Case # CM/29/18/HH

14 Appletree Walk, Clipping BN17 5QN

On Friday 26 October we noticed a yellow sign on the lamp post between our properties - 21 and 22 May Close - regarding planning permission for a single storey extension to 14 Appletree at the rear of our properties.

1 : 1250

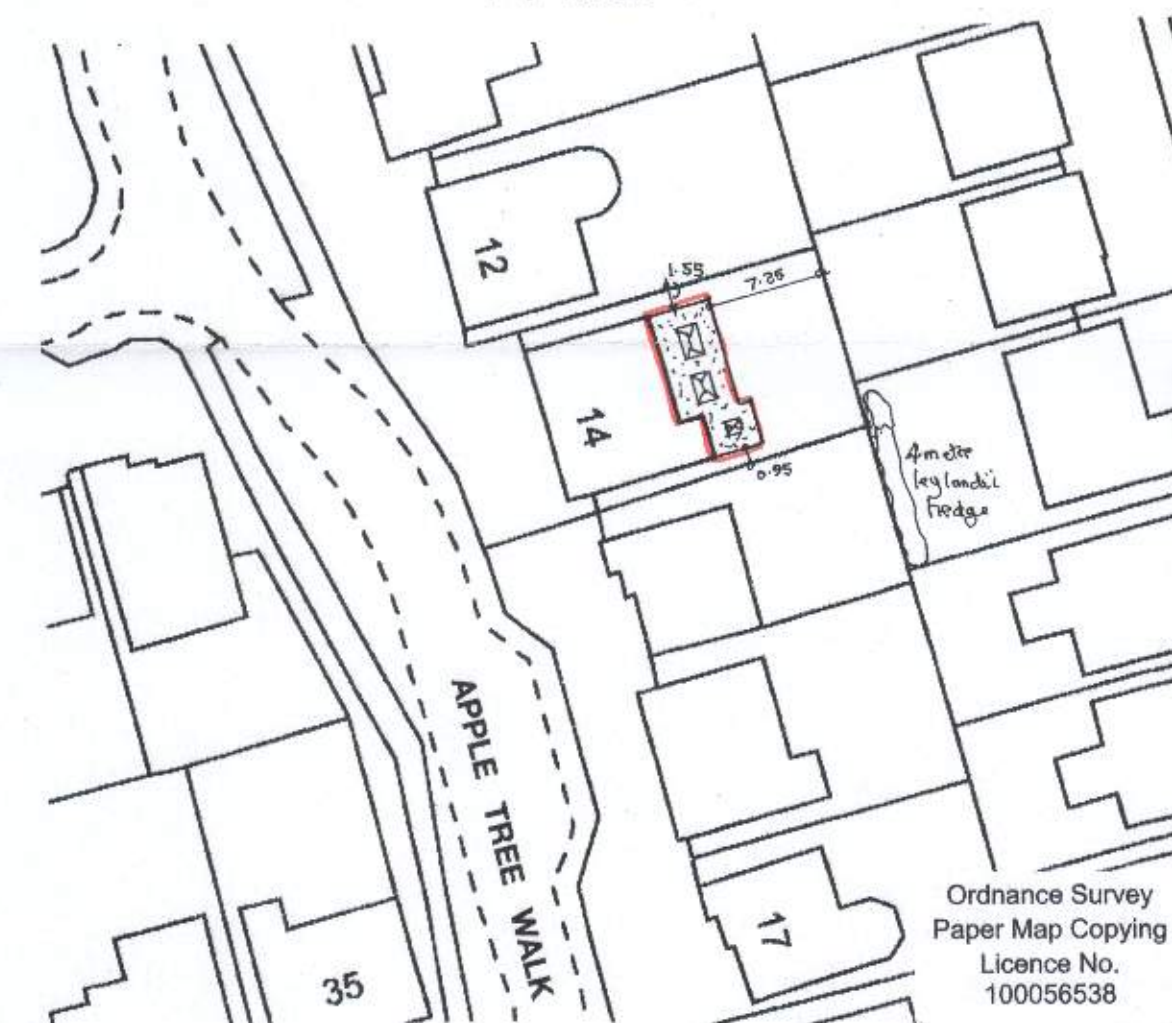
① On the aerial view of the house plots and roads my garden has a sketch of "4m Leylandii hedge" (I am unsure if this is 4m high or long!) But, and this is important, I do NOT have a Leylandii or any hedge along the boundary fence.

- Why was this considered important to include on plans?
- Why is this odd sketch on the wrong property?
- Why was this annotated?
